# Bramford to Twinstead Reinforcement

**Document 6.3.7.8.1 (B): ES Appendix 7.8 – Annex A Dormouse Draft Licence**

Date: 15 February 2024  
Our ref: 2023-63752-EPS-AD1-1  
(NATIONALLY SIGNIFICANT INFRASTRUCTURE  
PROJECT)

**DRAFT MITIGATION LICENCE APPLICATION STATUS:** SUBSEQUENT DRAFT APPLICATION  
**LEGISLATION:** THE CONSERVATION OF HABITATS AND SPECIES REGULATIONS 2017 (as amended)  
**NSIP:** Bramford to Twinstead Reinforcement  
**SPECIES:** Dormouse

ORIGINATOR DRAWING NO. **AAA_BTT_DormouseLicense_FigE2_Rev01** A3

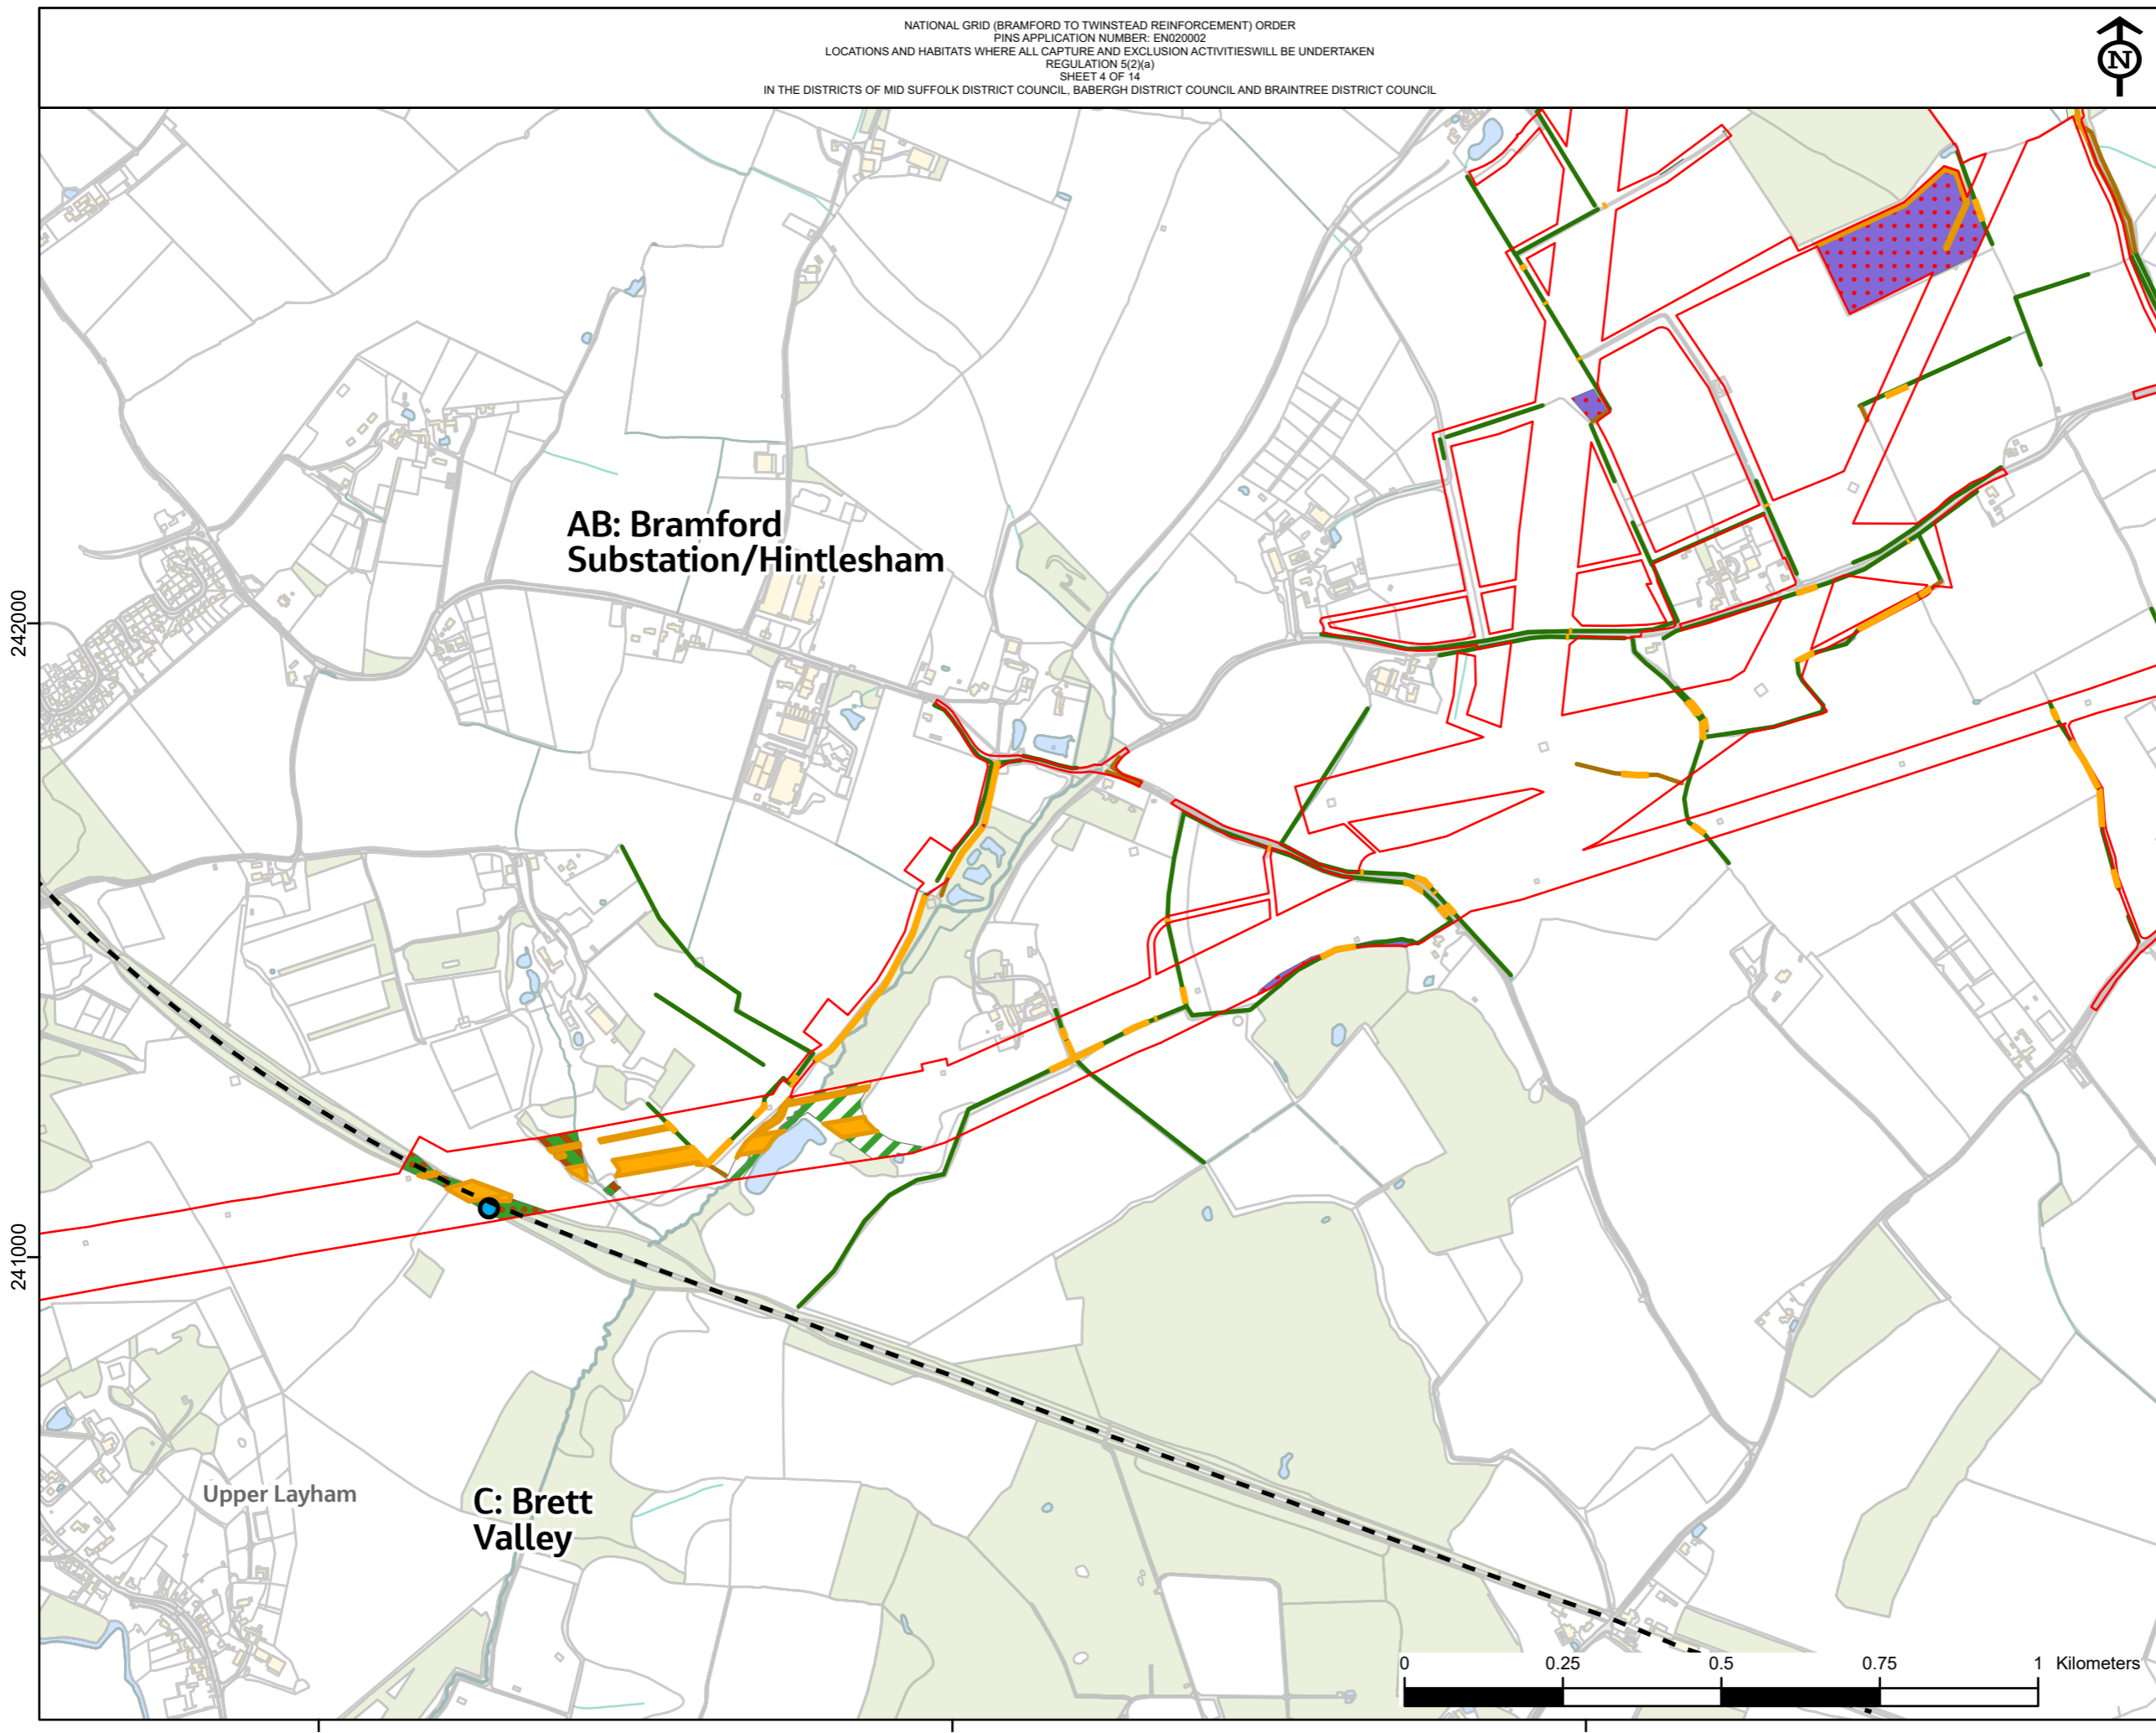
- Ensure that the figure is updated to show what areas will be cleared, and when, to clearly show the dormouse proposals as referenced in section E2 comments (above).
- Ensure that the figure is updated to show that all vegetation will be cleared in the direction towards retained suitable dormice habitat (a text box may be added to the figure to evidence this).
- Ensure that details regarding hand searches are referenced on the figure.
